DECISION DELEGATED TO HEAD OF PLANNING

Application No: H19-0136-22 **Applicant:** Mrs S Spridgeon

Proposal: Details of garden gates to be installed & additional tree planting
(Conditions 2 & 3 of H19-1145-21)

Location: 257 Broadgate Sutton St Edmund Spalding

Site Plan
Scale: 1:200

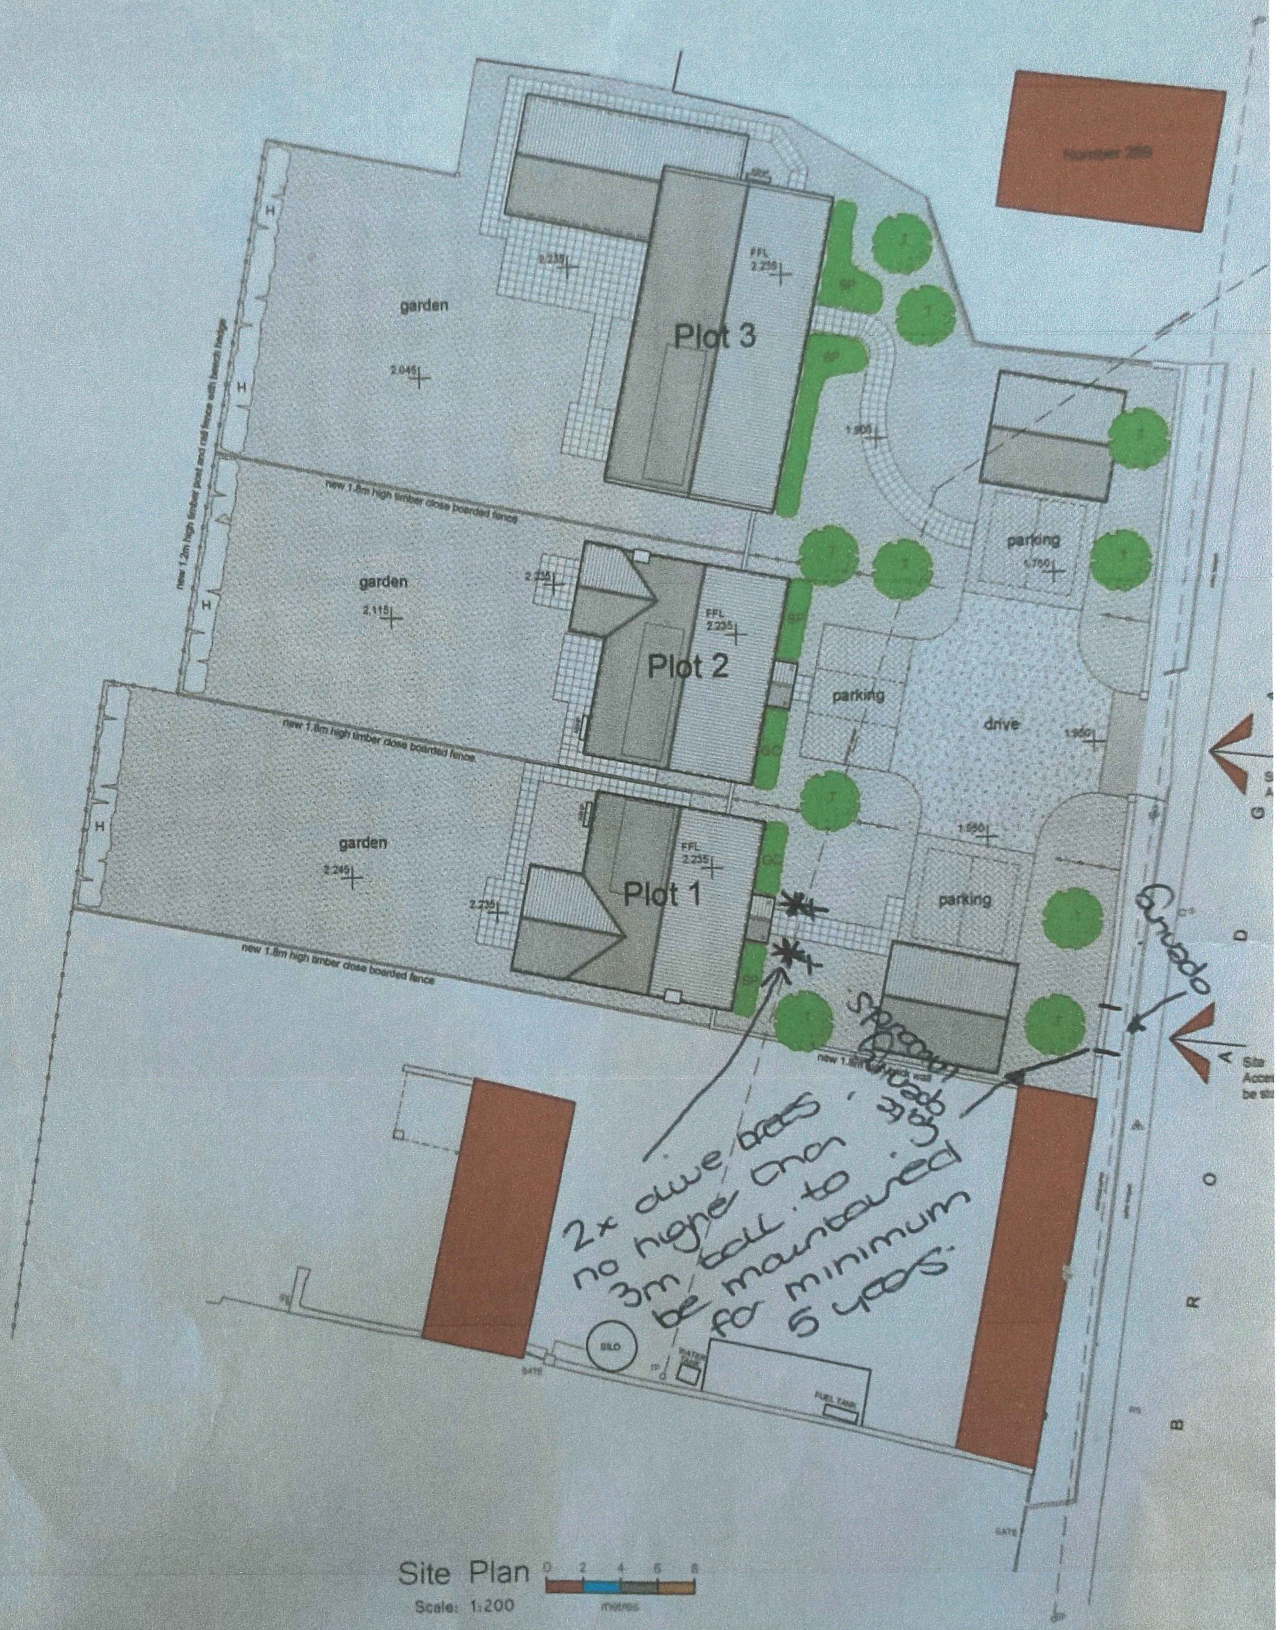
Condition 2 (Details of garden gates) - A traditional timber 5 bar gate is proposed that would open inwards and not over the footway/carriageway. It is acceptable in terms of appearance. LCC Highways have raised no objections on highway safety grounds.

Condition 3 (Landscaping) - Two Prunus "Accolade" trees would be omitted from the previously approved scheme as a result of the development. However, they would be replaced by two Silver Birch trees at the rear, plus two Olive trees. The revised scheme is considered satisfactory.

That conditions 2 & 3 of H19-1145-21 be discharged.
